STATE OF NORTH CAROLINA
DEPARTMENT OF TRANSPORTATION

October 29, 2004

Subject: **Nationwide Permit 14 Modification Application** for the Replacement of Bridge No. 14 over I-85/US29 on NC161 in Cleveland County. TIP No. B-3437, State Project No. 8.1801202, Federal Aid Project No. IMF-85-1(93)8. WSB Element 335604.1.1.

PROJECT REFERENCE NO. B-3437	SHEET NO. 4 of 6
R/W SHEET NO.	
ROADWAY DESIGN ENGINEER	HYDRAULICS ENGINEER
INCOMPLETE PLANS DO NOT USE FOR A/W ACQUISITION PRELIMINARY PLANS DO NOT USE FOR CONSTRUCTION

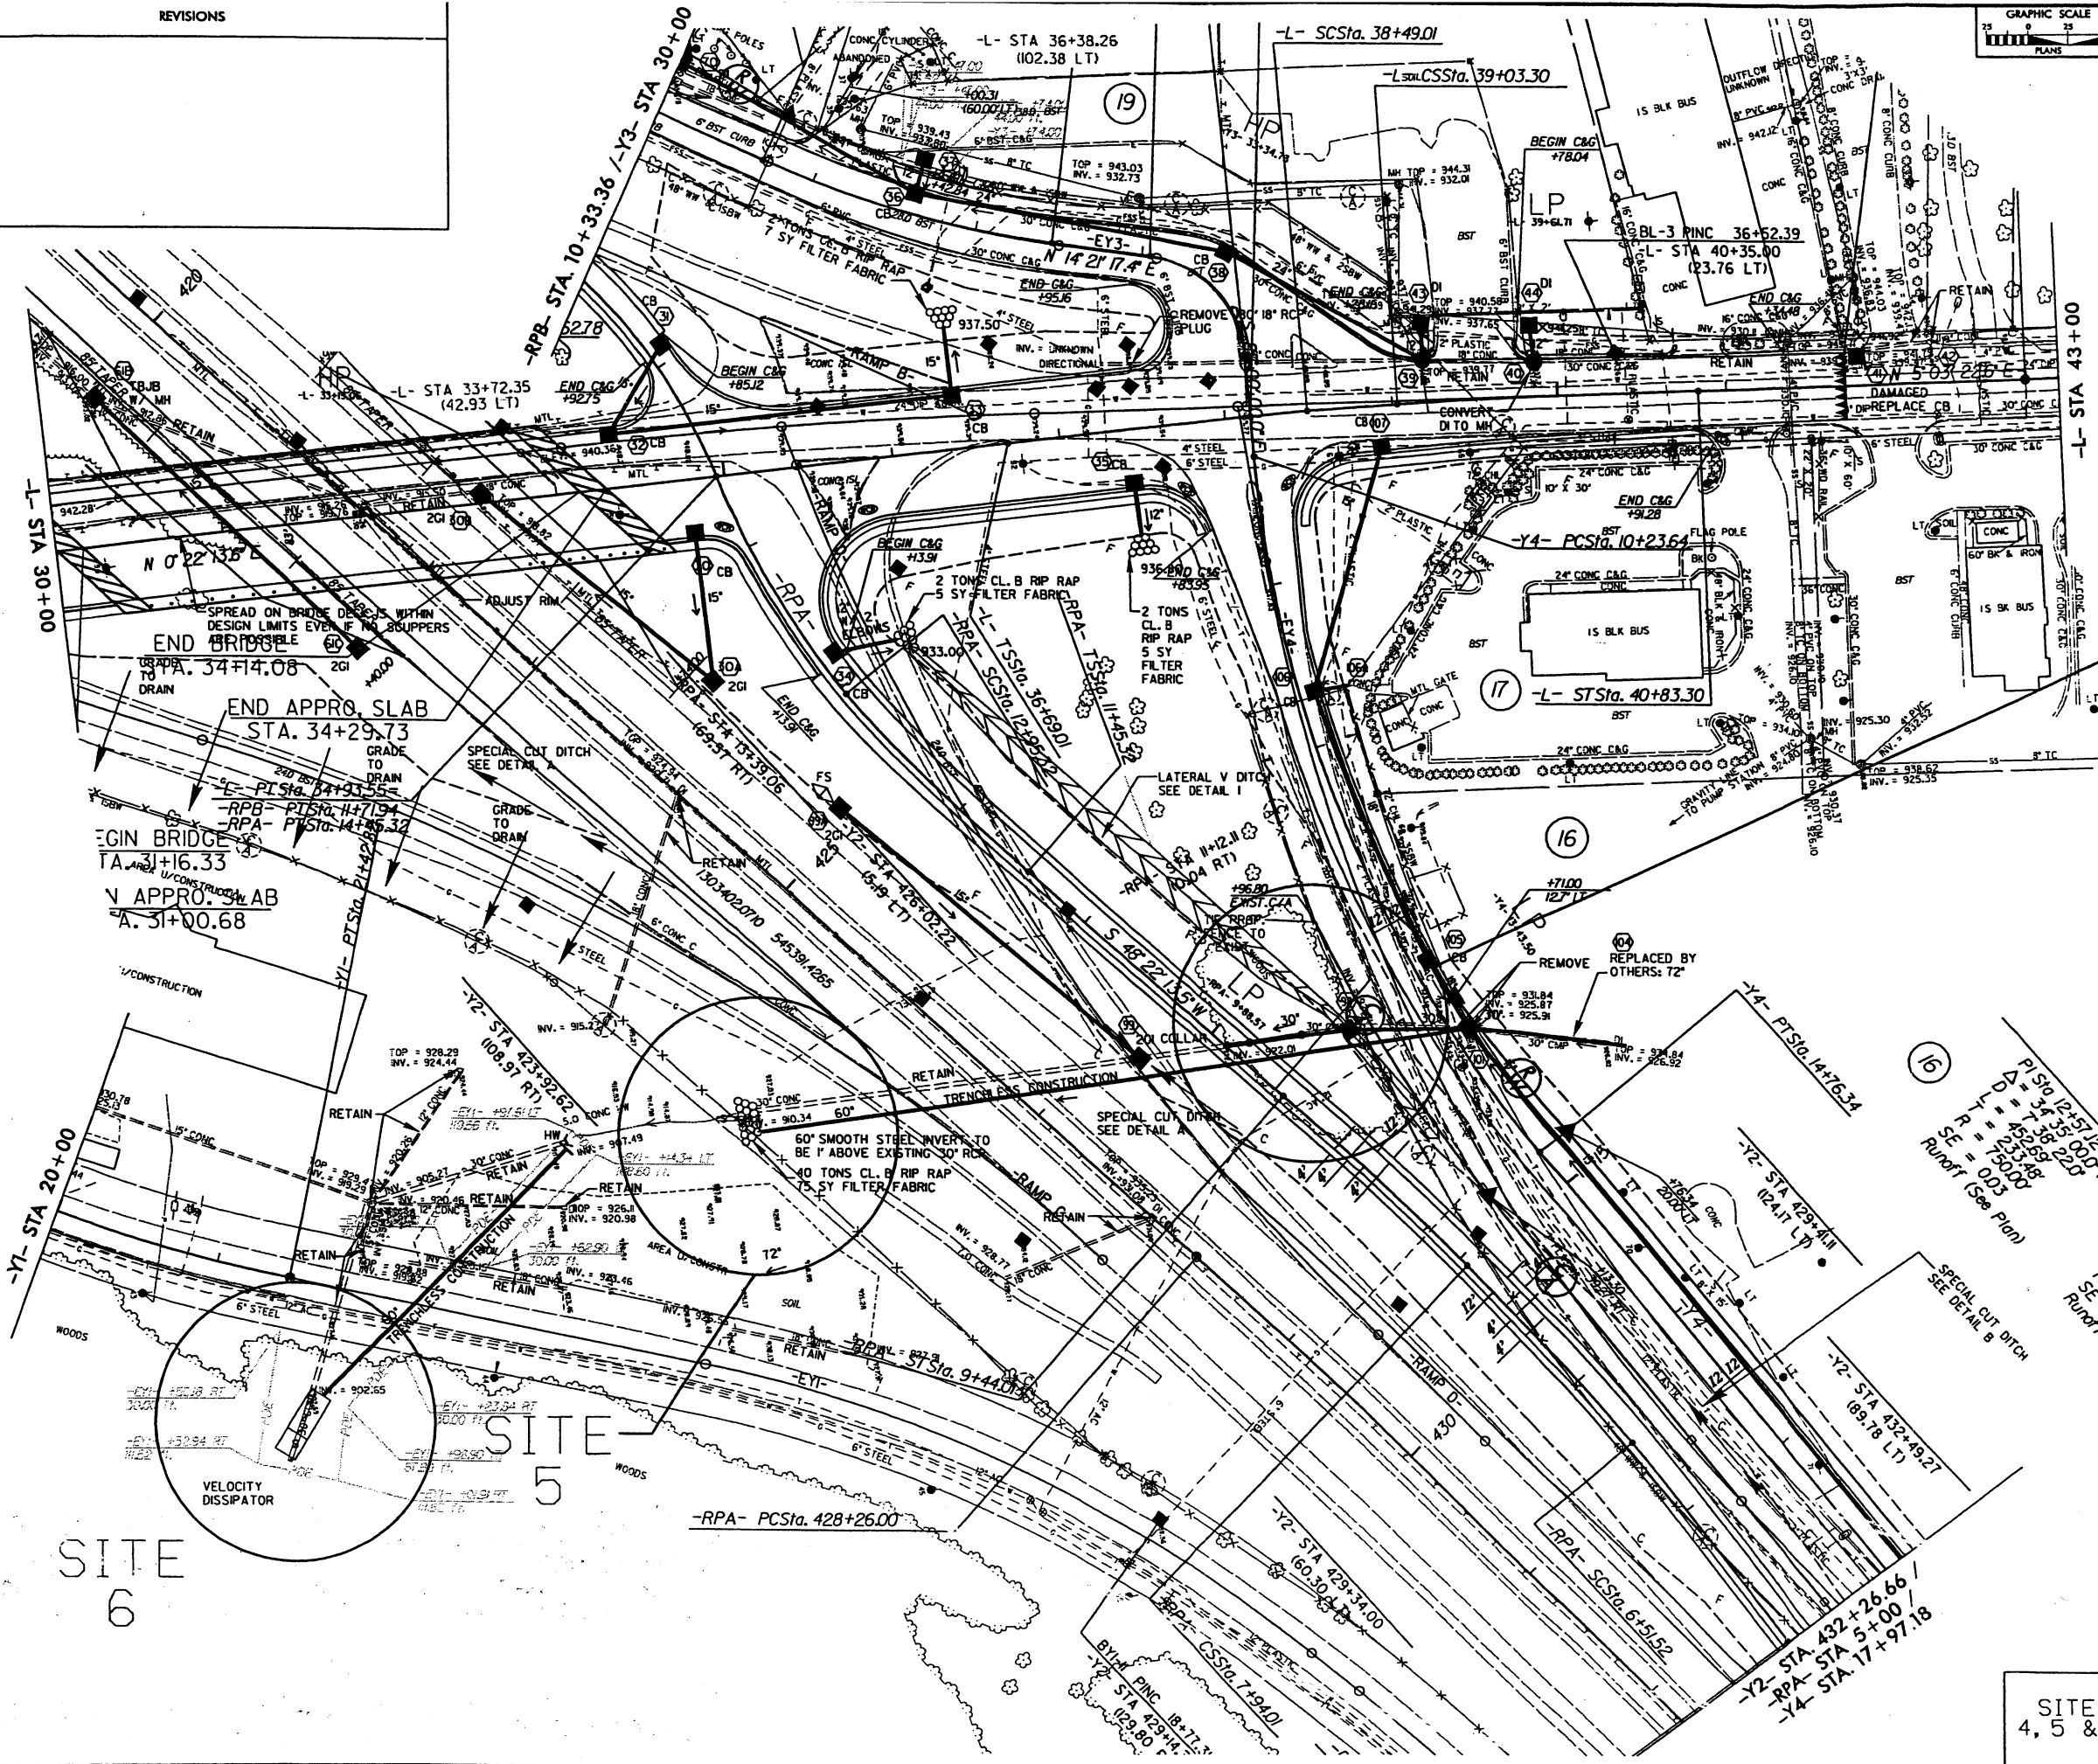
Site 5 at station -Y2-425+70 has proposed changes to Crowders Creek. The revised design is needed to provide erosion control, streambed stabilization, and stop headcutting. NCDOT proposes the following changes to Crowders Creek and the headwall at the downstream end of the channel (South):

- Placing Class II riprap into 100' of streambed to prevent erosion and headcutting.
- Extend and enlarge the southern headwall to keep it in place.

These proposed actions will serve to stabilize the stream, slow down the velocity of water, and prevent erosion.
